**Subject:** Rezoning Petition Review

**Date of Review:** May 26, 2022 (*Revised June 17, 2022*)

**Rezoning Petition #:** 21-285

**Location of Property:** Approximately 0.15 acres located in the southern quadrant of the intersection of Cleveland Ave and E Worthington Ave, east of South Blvd.

JOB NO.: 2021-119  
 DRAWN BY: MDV  
 DATE: 12.22.21  
 SCALE: 1"=10'  
**SCHEMATIC SKETCH PLAN**  
**RZ.1**

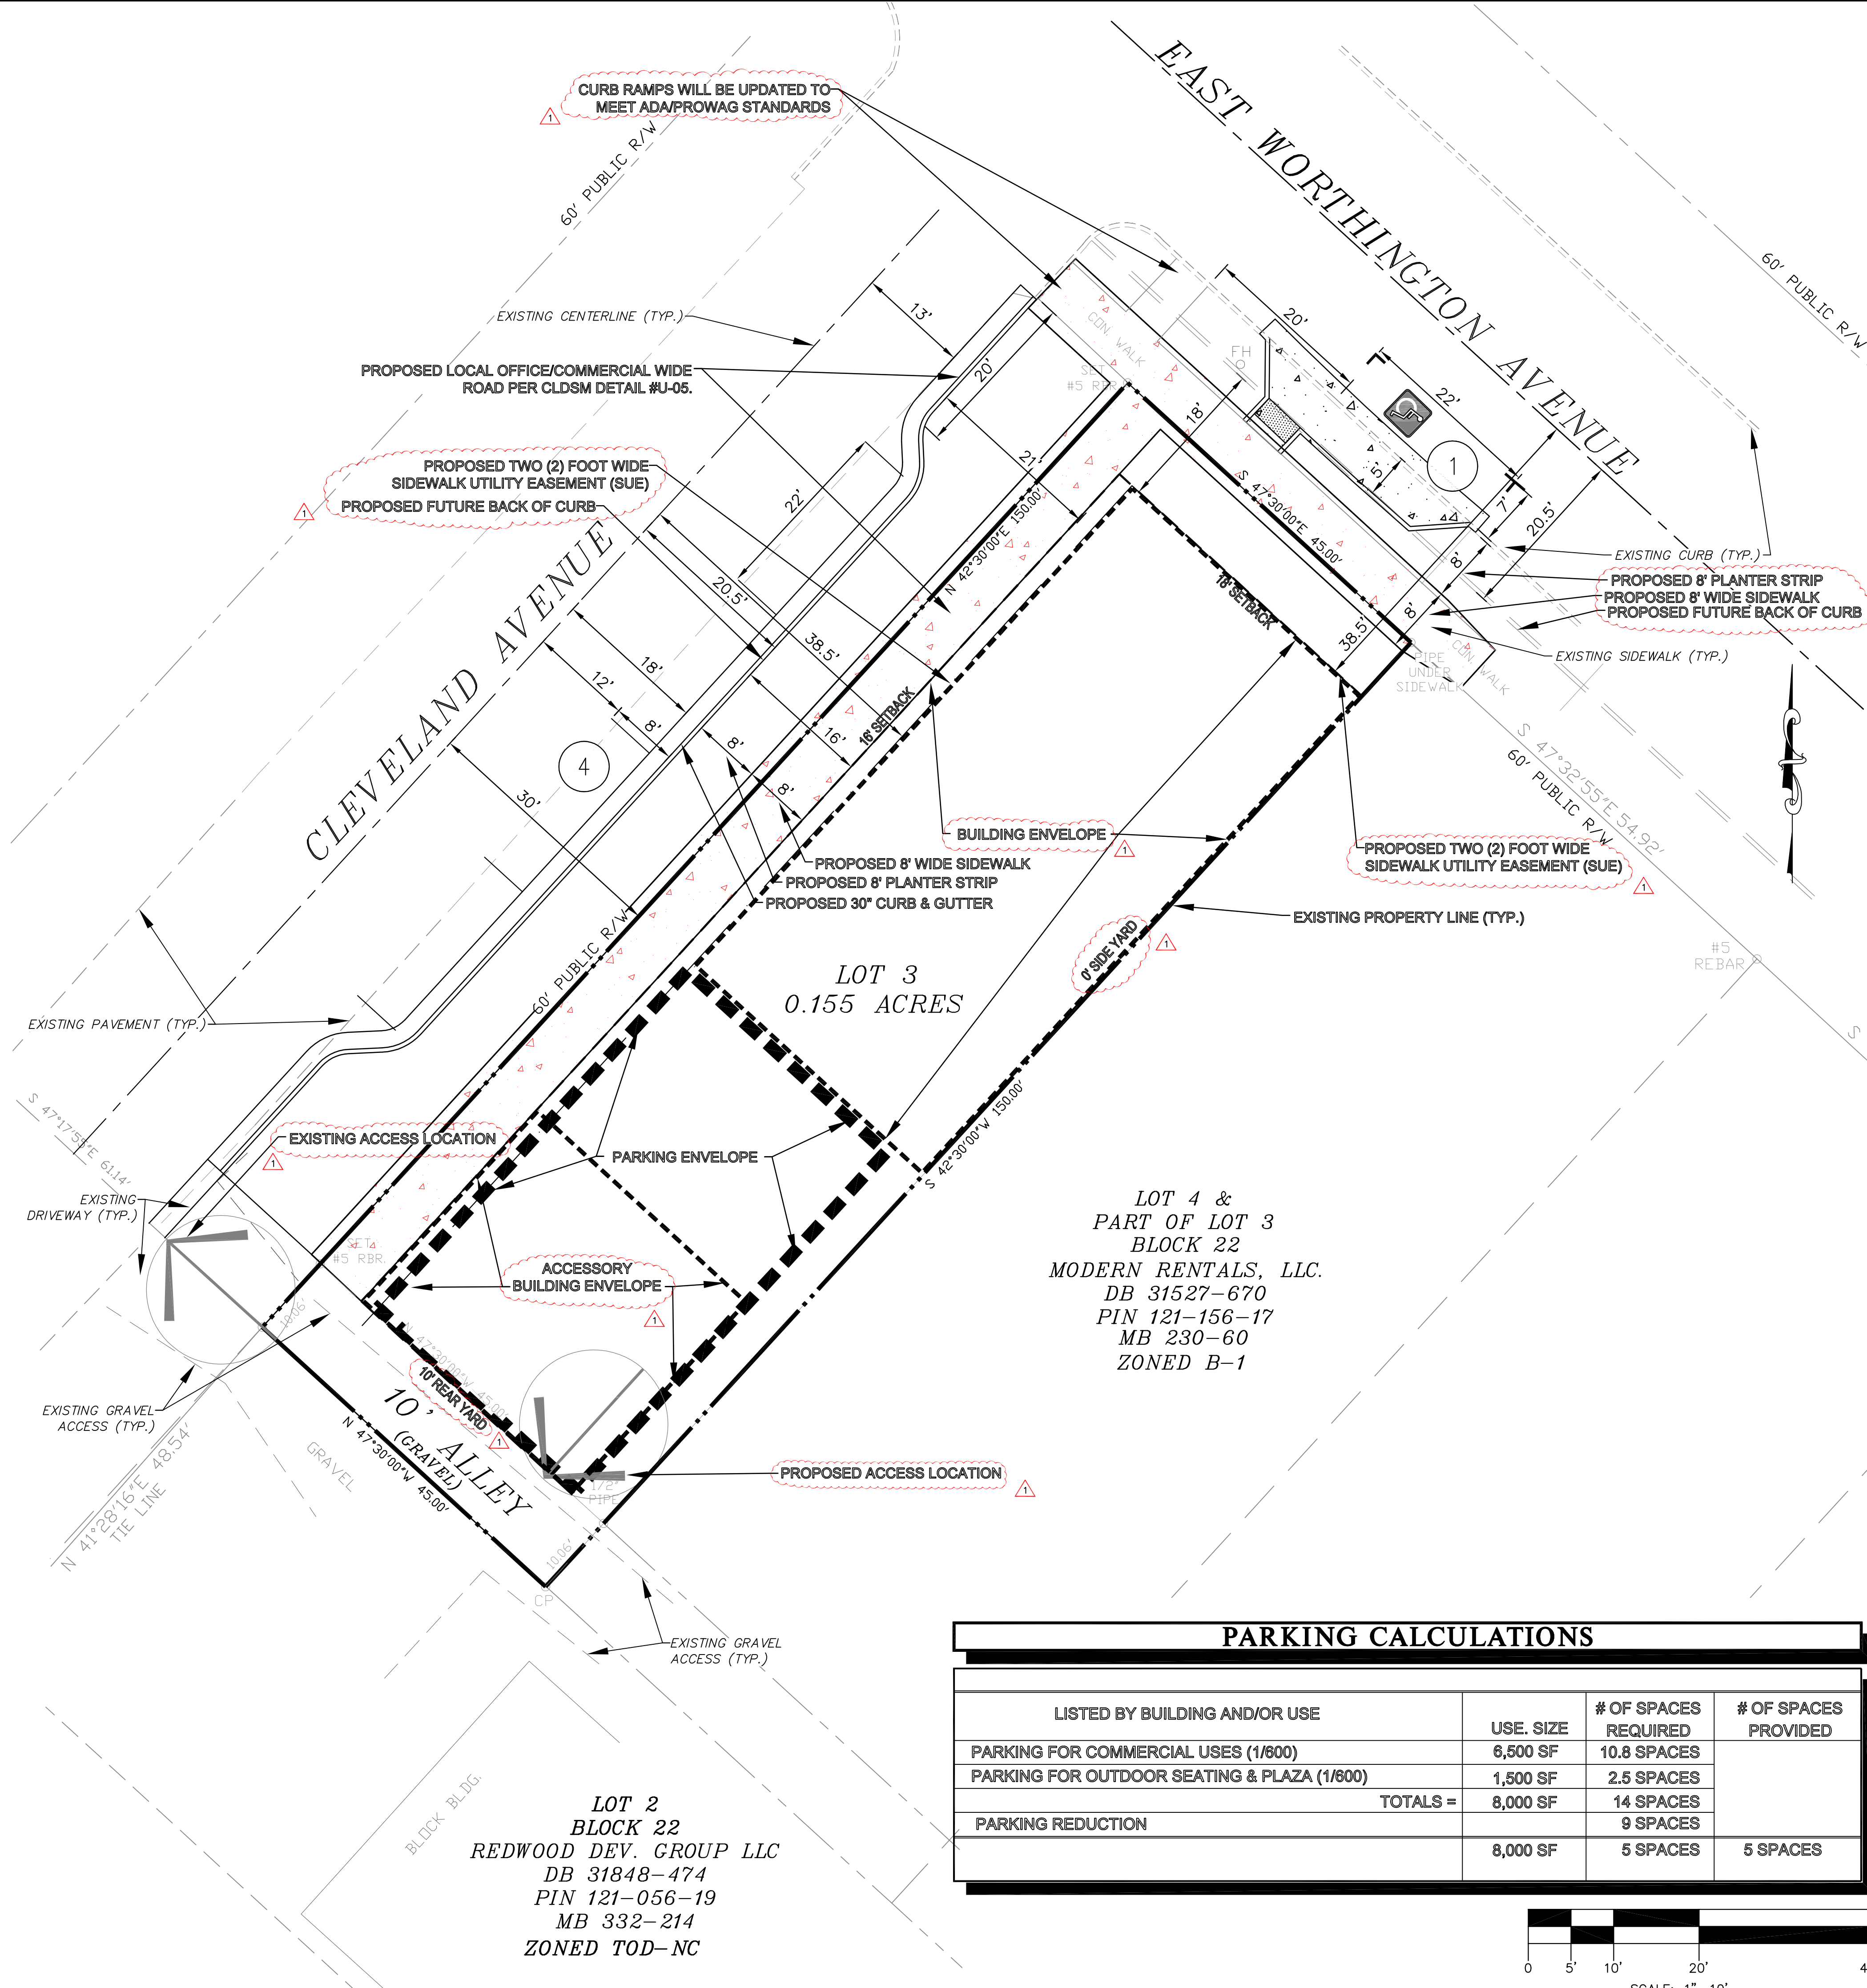
PCSO compliance is not determined during the rezoning process. Please remove the following sentence from note VI.1 under "Environmental Features": *Site work already completed prior to this rezoning plan shall be deemed in compliance.*

**This property drains to Upper Little Sugar Creek, which is an impaired/degraded stream, and may contribute to downstream flooding. This project has the opportunity to mitigate future impacts to this stream, therefore, Storm Water recommends placing the following notes on the plan:**

(I) Storm Water Quality Treatment

For defined watersheds greater than 24% built-upon area (BUA), construct water quality stormwater control measures (SCMs) designed for the runoff generated from the first 1-inch of rainfall for all new and redeveloped BUA associated with the project. SCMs must be designed and constructed in accordance with the Charlotte-Mecklenburg BMP Design Manual.

(II) Volume and Peak Control

For defined watersheds greater than 24% built-upon area, control the entire volume for the 1-year, 24-hour storm for all new and redeveloped BUA associated with the project. Runoff volume drawdown time shall be in accordance with the Charlotte-Mecklenburg BMP Design Manual.

For commercial projects with greater than 24% BUA, control the peak to not exceed the predevelopment runoff rates for the 10-yr, 6-hr storm and perform a downstream flood analysis to determine whether additional peak control is needed and if so, for what level of storm frequency, or if a downstream analysis is not performed, control the peak for the 10-yr and 25-yr, 6-hour storms.

For residential projects with greater than 24% BUA, control the peak to not exceed the predevelopment runoff rates for the 10-year and 25-year, 6-hour storms or perform a downstream analysis to determine whether peak control is needed, and if so, for what level of storm frequency.
